OXFORDSHIRE COUNTY COUNCIL'S RESPONSE TO CONSULTATION ON THE FOLLOWING DEVELOPMENT PROPOSAL

Application no: 21/01123/F

Proposal: Demolition of existing buildings. Construction of replacement business units and associated external works. (Re-submission of 20/01127/F)

Location: Hatch End Old Poultry Farm, Steeple Aston Road, Middle Aston

DRAWING TITLE	- Proposed Site Plan - Overall		
CONTRACT	- The Hatchery		
MODELLED BY	- HS	ISSUE DATE	- 10.09.21
CONTRACT NO	- JOB139990	SCALE	- 1:500 @A1
DRAWING No	- 139990_P102	REVISION No.	E

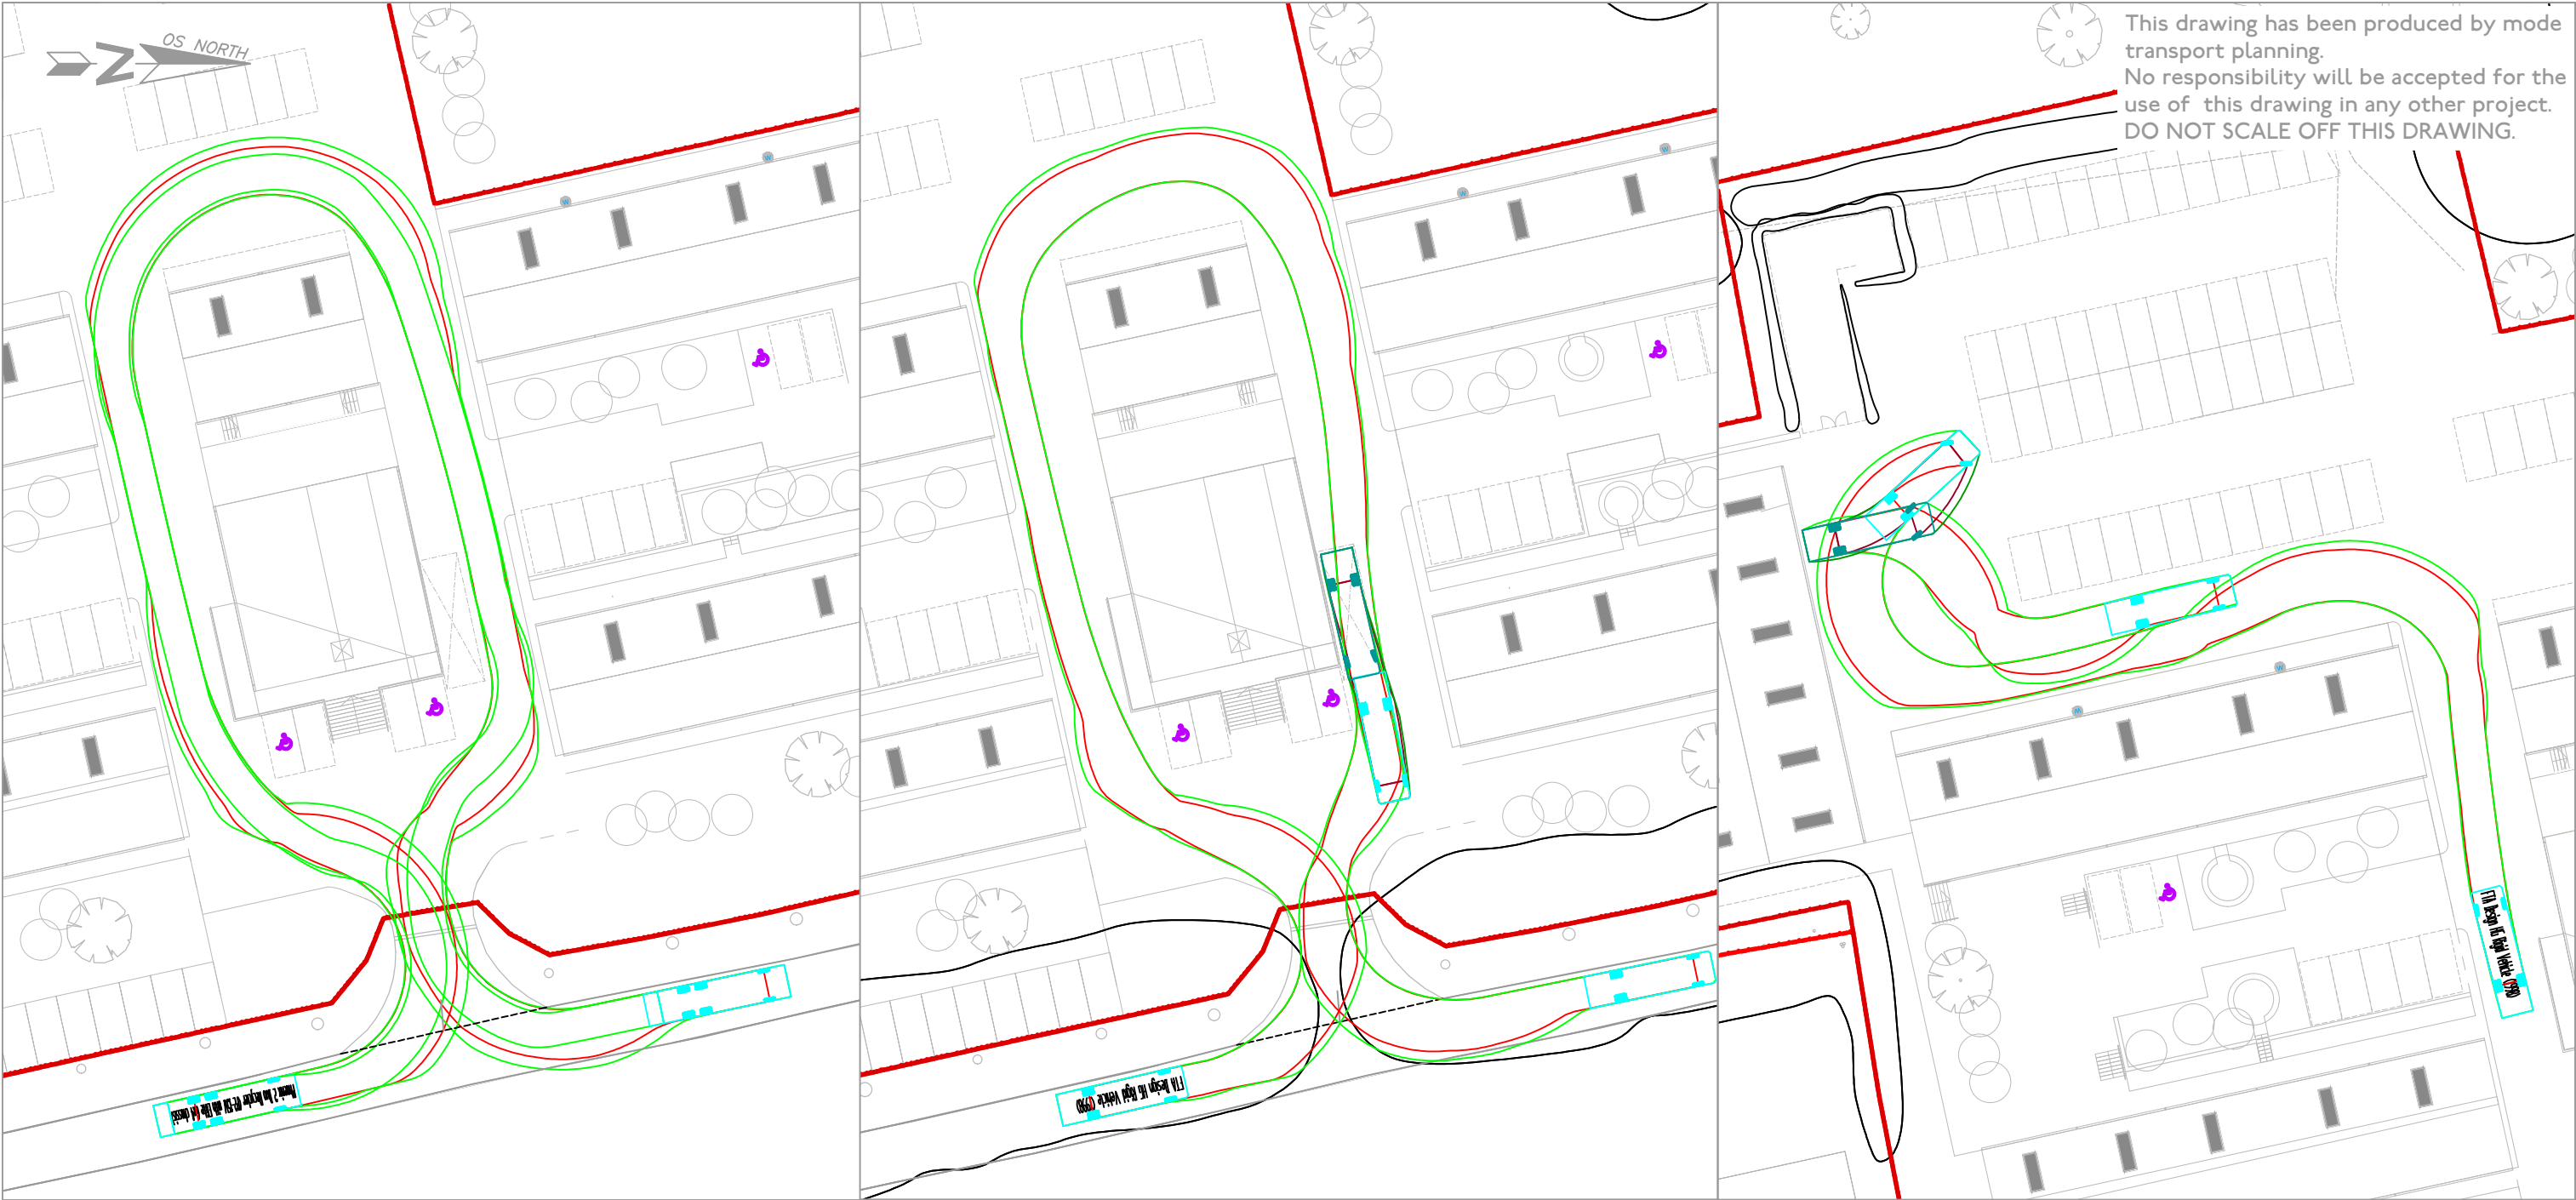
- The revised parking layout and quantum is acceptable in principle. However, the number of electric vehicle (EV) charging points falls short of the County's standards. Policy EVI 8 of the Oxfordshire Electric Vehicle Infrastructure Strategy adopted in March 2021 states that:

The provision of 12 EV charging points represents only 16% of the 74 parking spaces proposed. **Under the County's standards a minimum of 19 EV charging points is required.** This provision can be amended in discharge of a condition of planning permission.
